# COLORADO GEOLOGICAL SURVEY

February 13, 2018

**Subject: Windingwalk Filings 1 and 2 PUD Development/ Preliminary Plan; Final Plat Winding Walk Filing 1 File Number PUDSP182; El Paso County, CO; CGS Unique No. EP-18-0037**

TEST BORING LOCATION PLAN
 WINDINGWALK FILINGS 1 AND 2, AND
 STONEBRIDGE THE ENCLAVE FILINGS 4 AND 5
 EL PASO COUNTY, CO.
 FOR: TECH CONTRACTORS

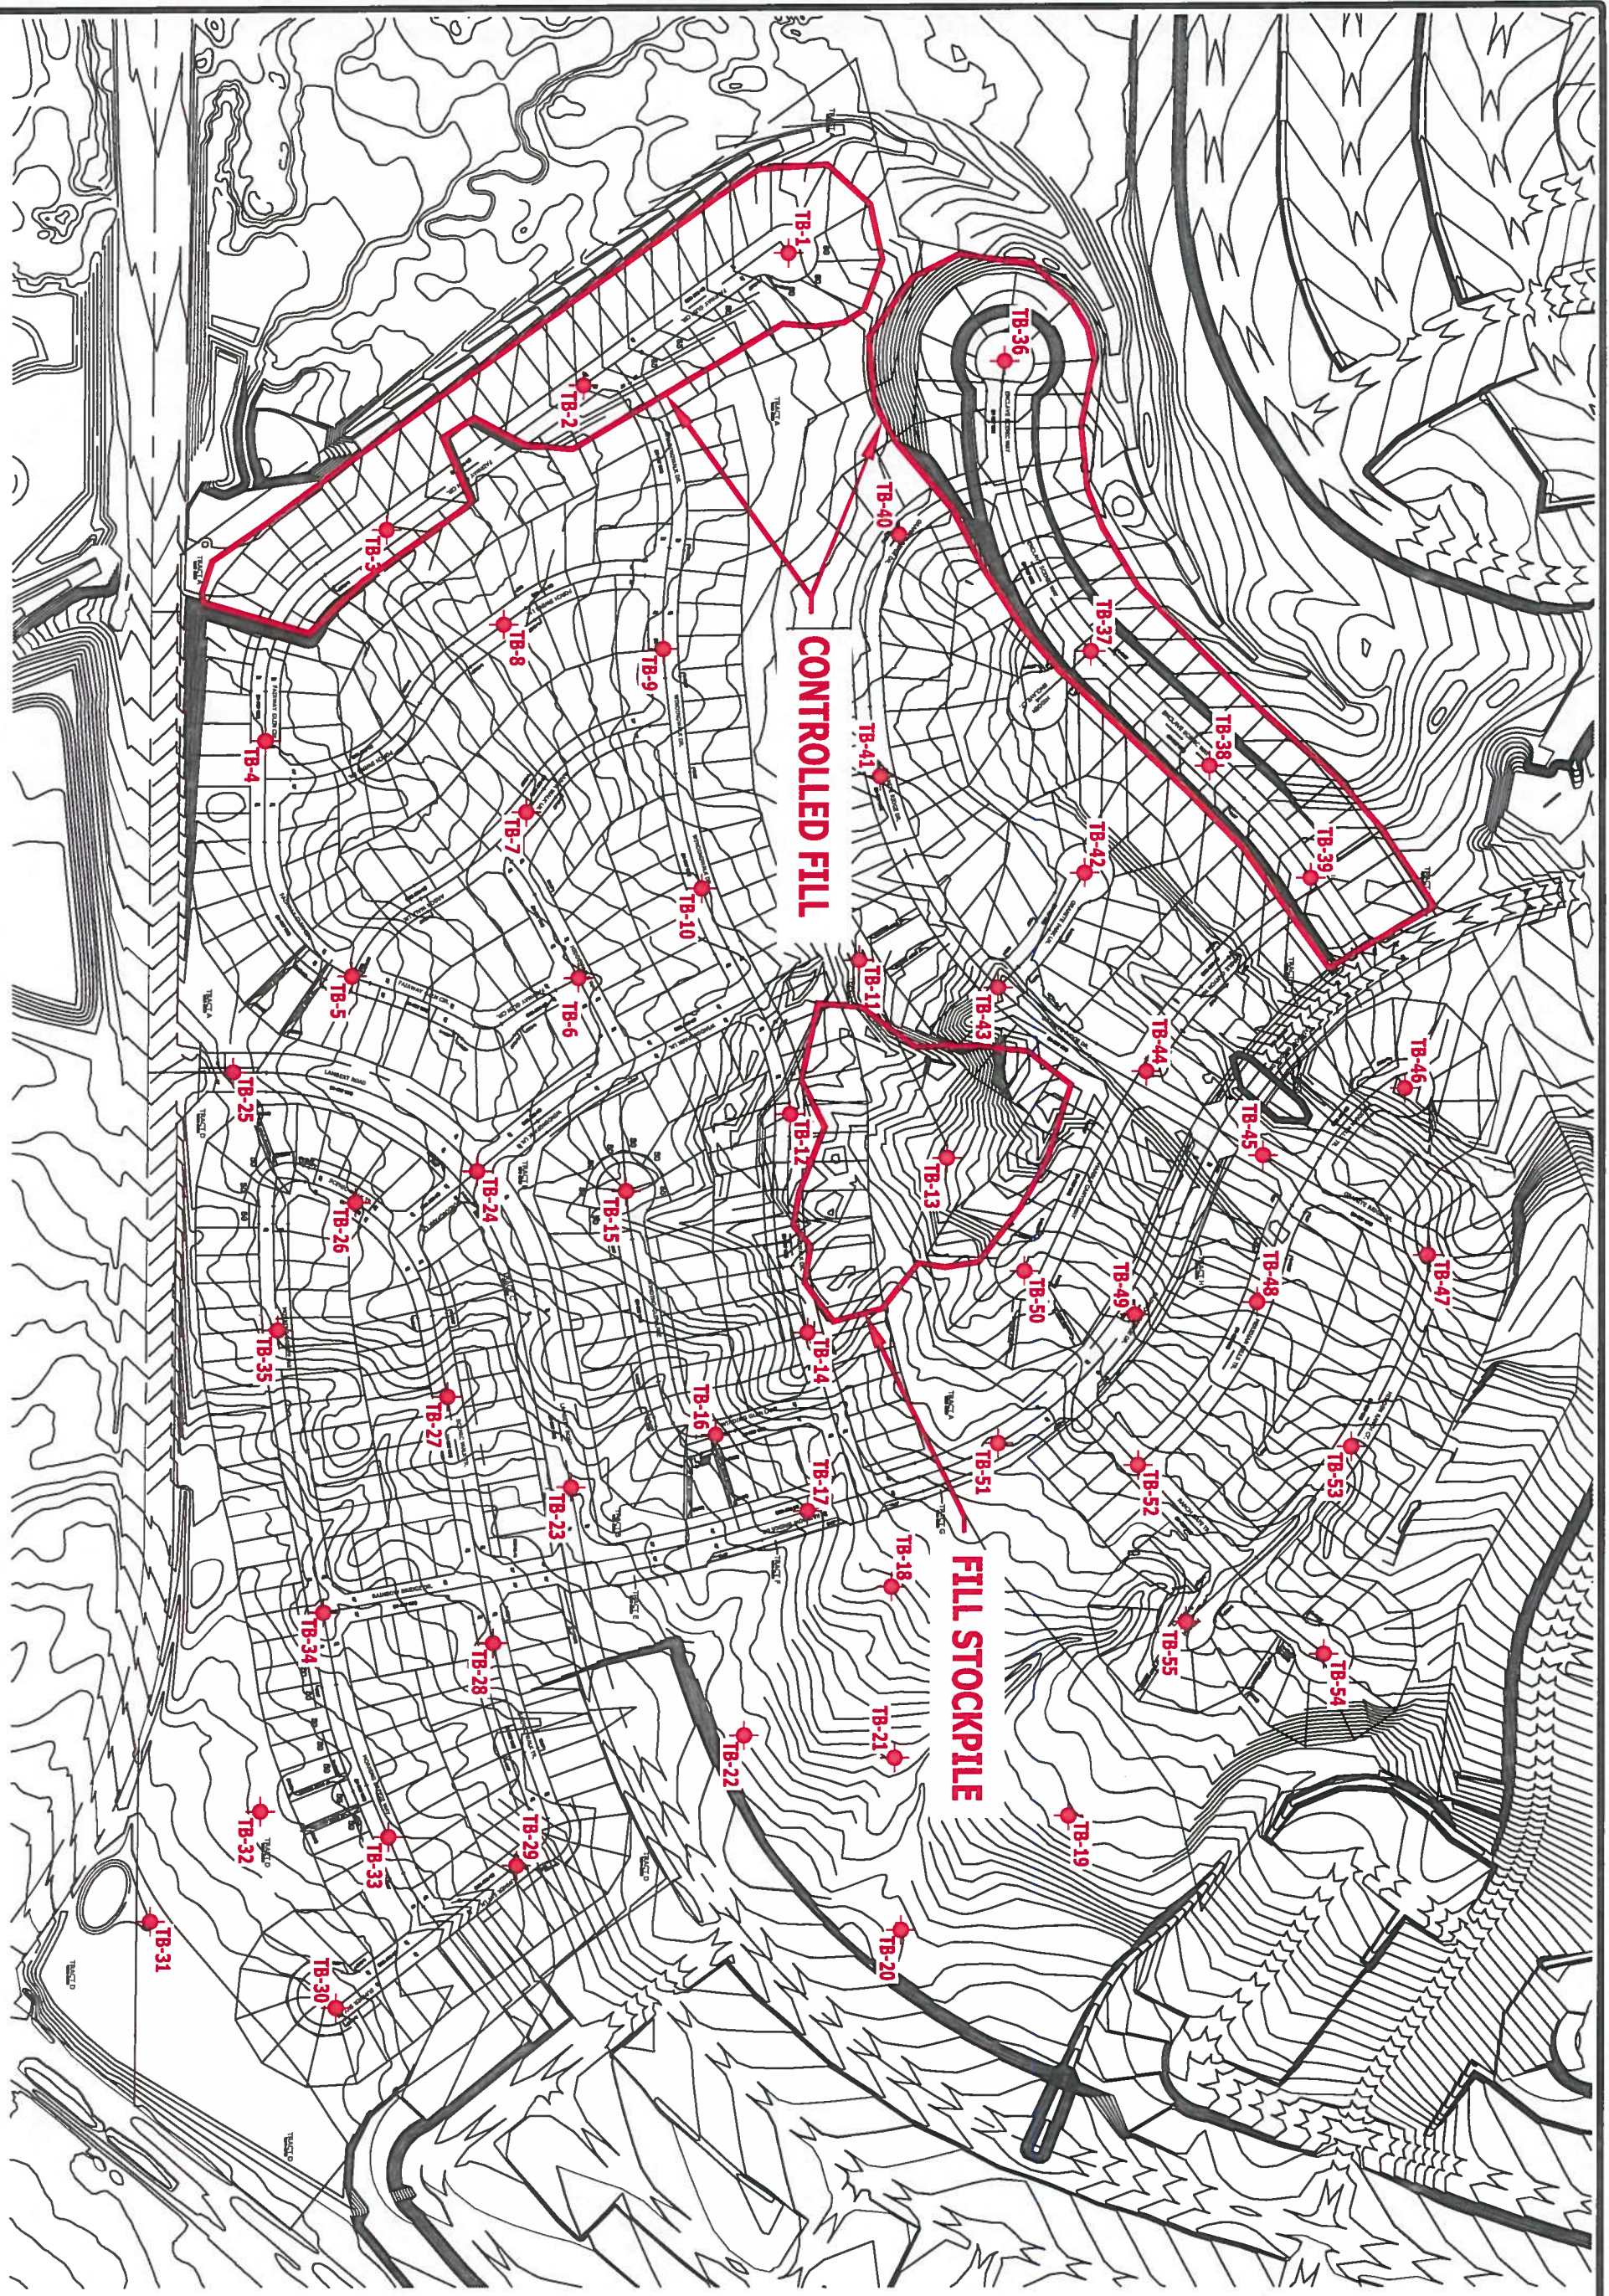
The subsurface investigation includes mapping of fill on the site. The site specific geologic report should include mapping of surficial geology including areas with loose and potentially collapsible soils and all other relevant surface geologic materials at this location. The mapping should also indicate locations of potential geologic hazards such as wind and water erosion, shallow groundwater and shallow bedrock. *The proposed lots should be overlaid on the geologic and geologic hazard maps prepared as part of the required geology and soils report.*

**Fill:** Both engineered fill and non-engineered fill has been identified on the site in the subsurface investigation. Complete removal of the non-engineered fill and debris is recommended. The report states that the fill located along Enclave Scenic Way and Fairway Glen Circle (shown on their Figure 2) was observed and tested and that records of the fill will be provided as required. Records of fill should be required prior to approval of Plat/preliminary plan. All fill should be considered non-engineered unless the testing records are provided and any plans to leave fill in place should be made after receiving fill placement records.
